Please ask for: Mrs D Johnson
Email: daun.johnson@arun.gov.uk
Telephone: 01903 737762
Our Ref: P/35/21/PL
Your Ref:
Date: 15th March 2021

Application for Planning Permission

Development: Material change of use of land from agricultural use to use for open space. This application is in part a Departure from the Development Plan, affects a Public Right of Way & is in CIL Zone 5 (Zero Rated) as other development.

Location: Land At Summer Lane Pagham

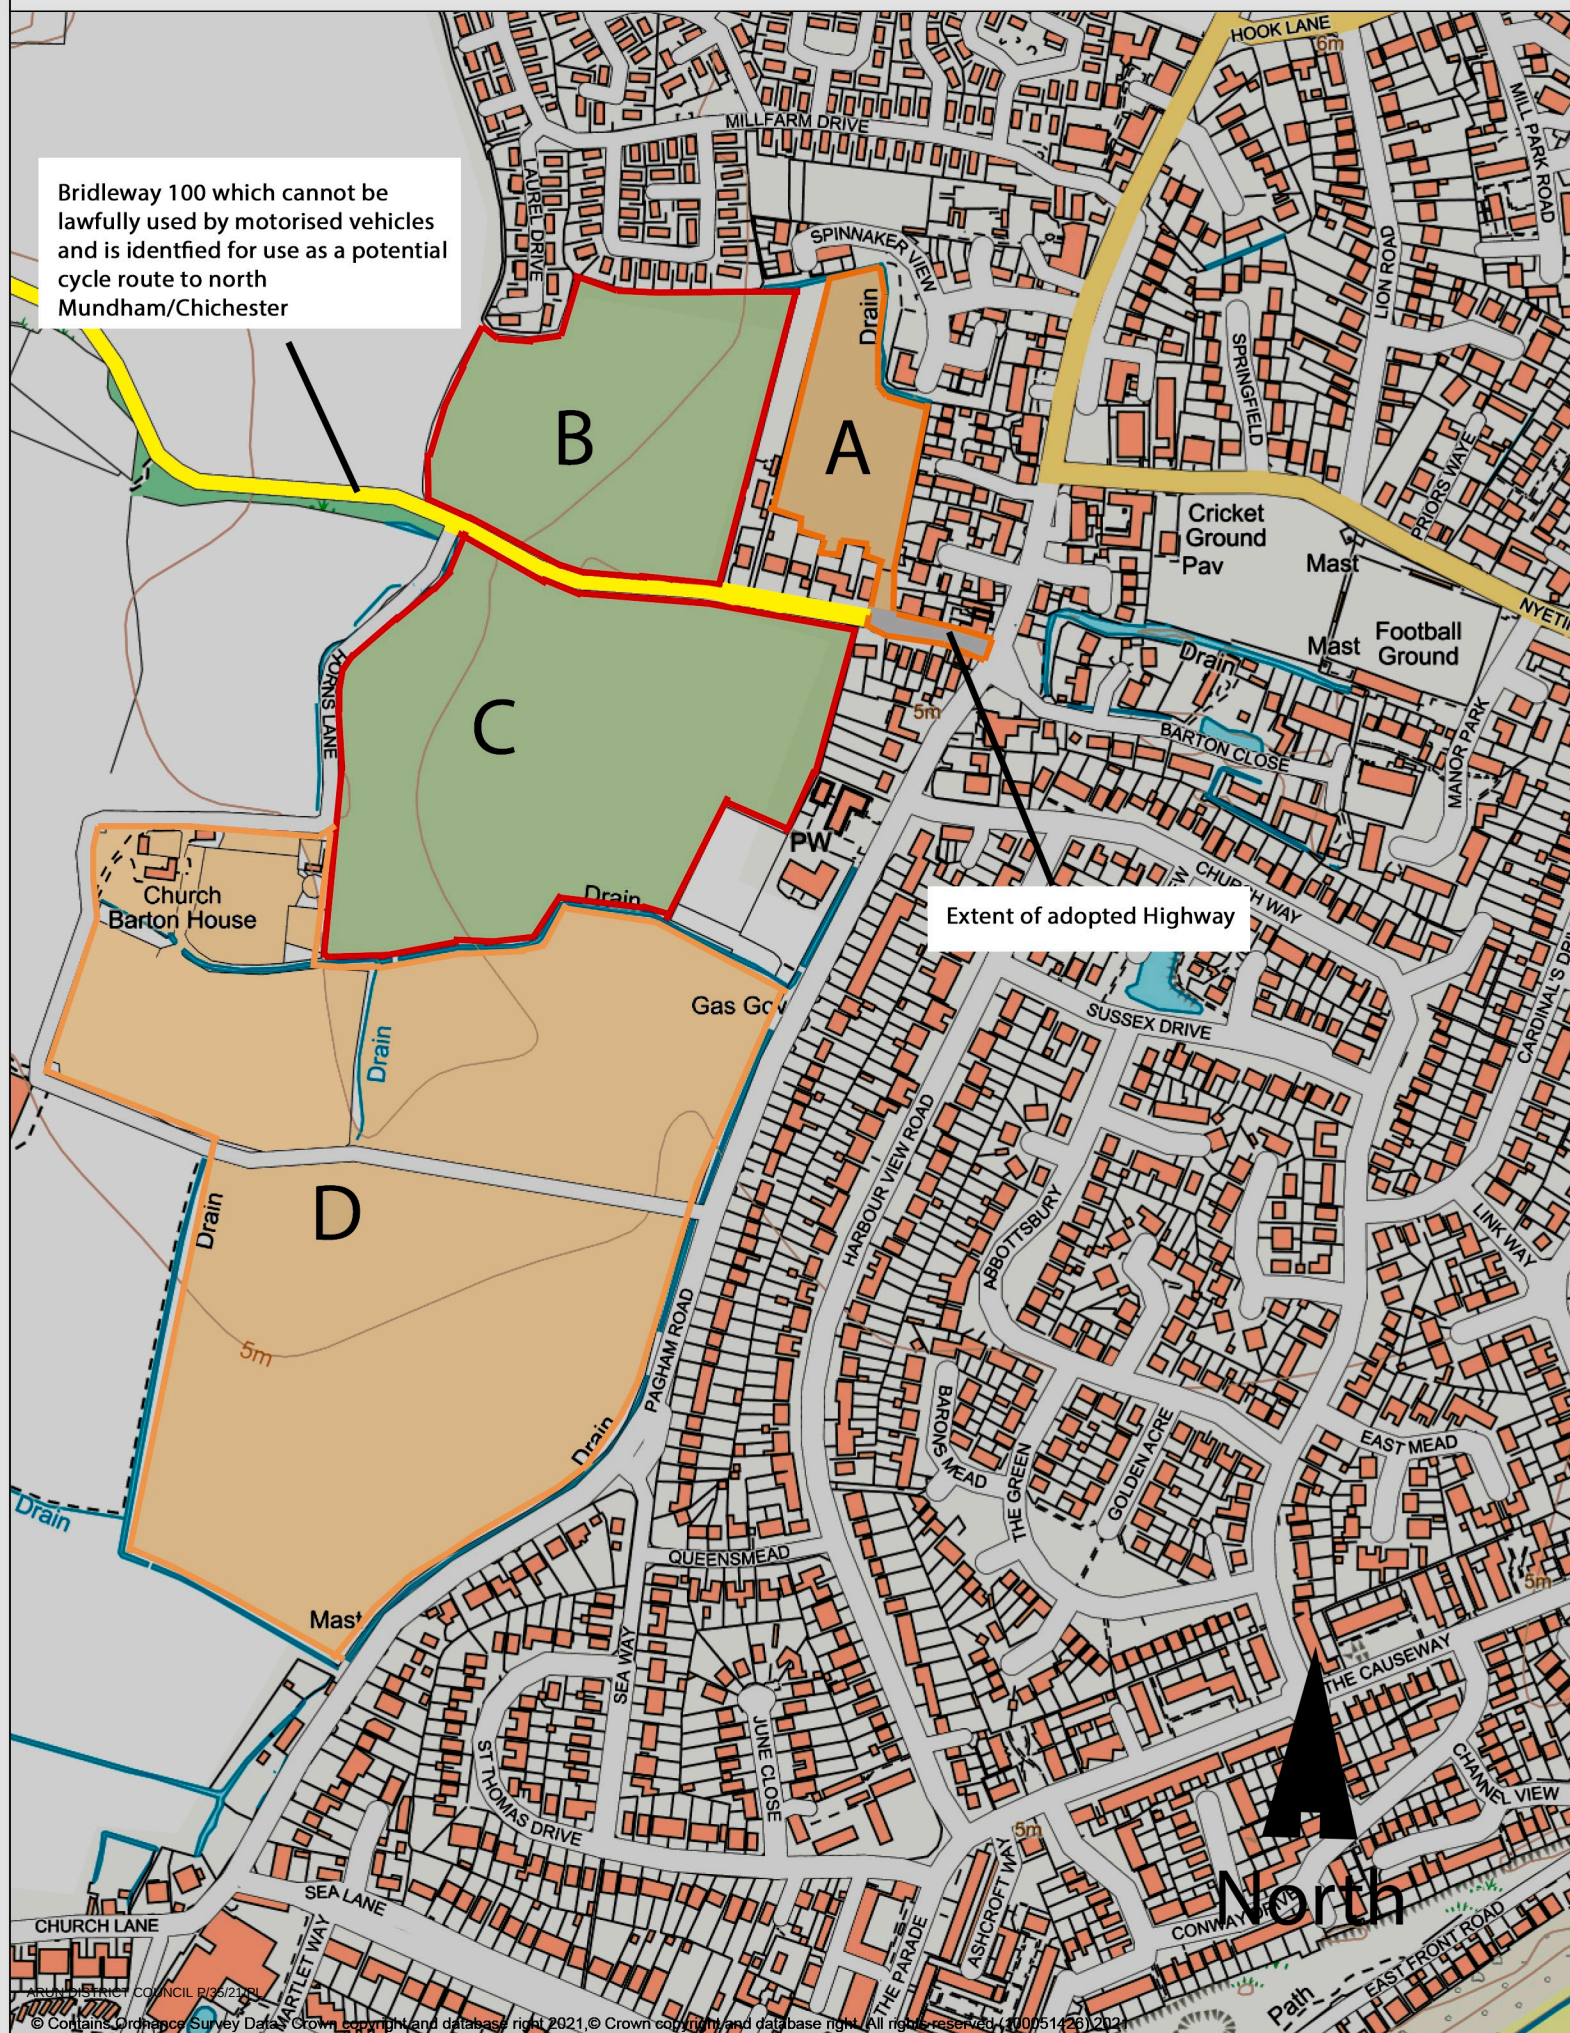
Please provide a north point on the location plan.
